WEST SUSSEX COUNTY COUNCIL CONSULTATION

TO:	Arun District Council FAO: Anita Gardner
FROM:	WSCC - Highways Authority
DATE:	7 October 2020
LOCATION:	57 River Road Littlehampton BN17 5DD
SUBJECT:	LU/247/20/PL Partial demolition of existing building, retention of boundary wall & street facade, partial demolition of boundary wall to incorporate new pedestrian gateway & gate, erection of 6 No. flats in 2 blocks connected by shared stair & lift core, on site parking yard for 8 No. cars & 8 No. cycles & space for communal refuse & recycling bins. This application affects the character & appearance of the Littlehampton River Road Conservation Area & is in CIL Zone 4 (Zero Rated) as flats.
DATE OF SITE VISIT:	n/a
RECOMMENDATION:	More Information
S106 CONTRIBUTION TOTAL:	n/a

TITLE: PROPOSED GROUND FLOOR PLAN

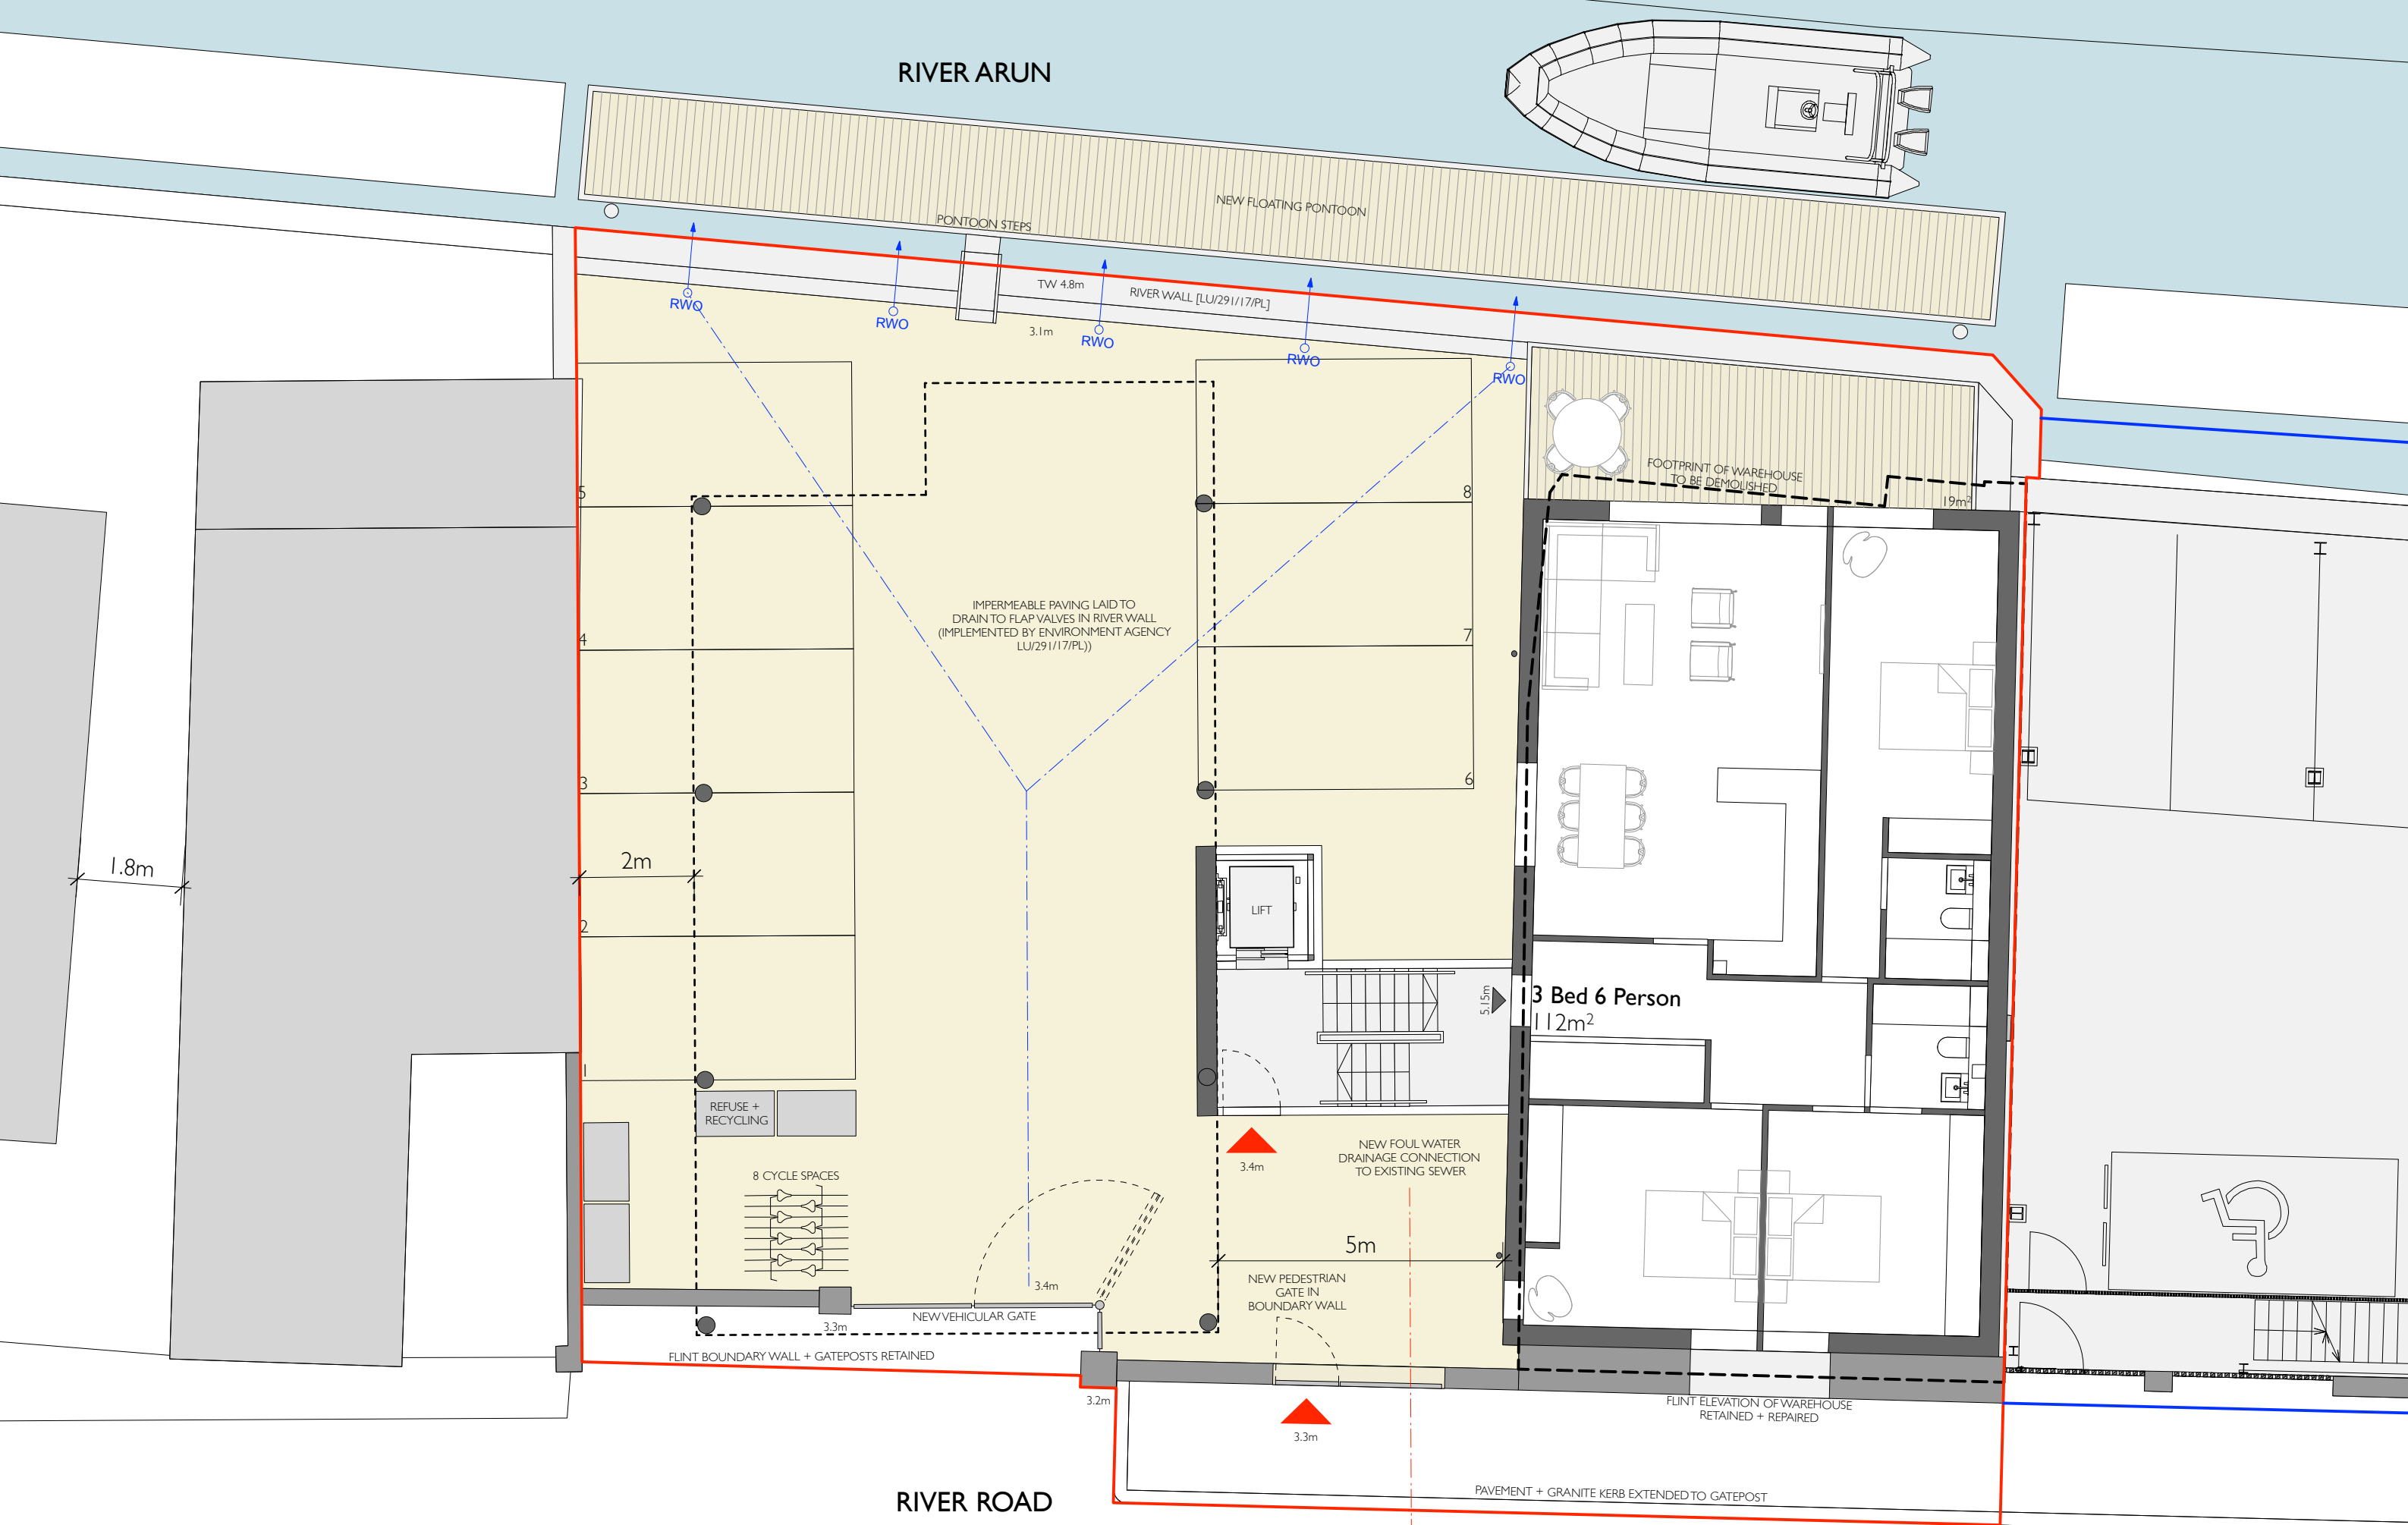
The site is currently accessed via an existing gated entrance which will be retained for the residential use. The area fronting the existing gate is not maintained by the LHA as public highway, and the applicant's plans appear to indicate that an area of the access is not within their ownership. As such, there could be a potential third party land issue at the access point. Whilst not strictly a planning consideration, should this land be required for vehicular visibility, splays passing through this land could not be secured in perpetuity. Visibility splays would be required should the proposal represent an intensification of use of the land over the existing warehouse use. The applicant is requested to provide details of vehicular trip generation associated with the existing use of the site and anticipated trip generation associated with the proposed residential use.

The applicant also intends to extend the existing footway and kerb line to the western gatepost. This is currently demonstrated within the applicant's own land - is it the applicant's intention for the footway to be adopted as publicly maintainable highway by WSCC?
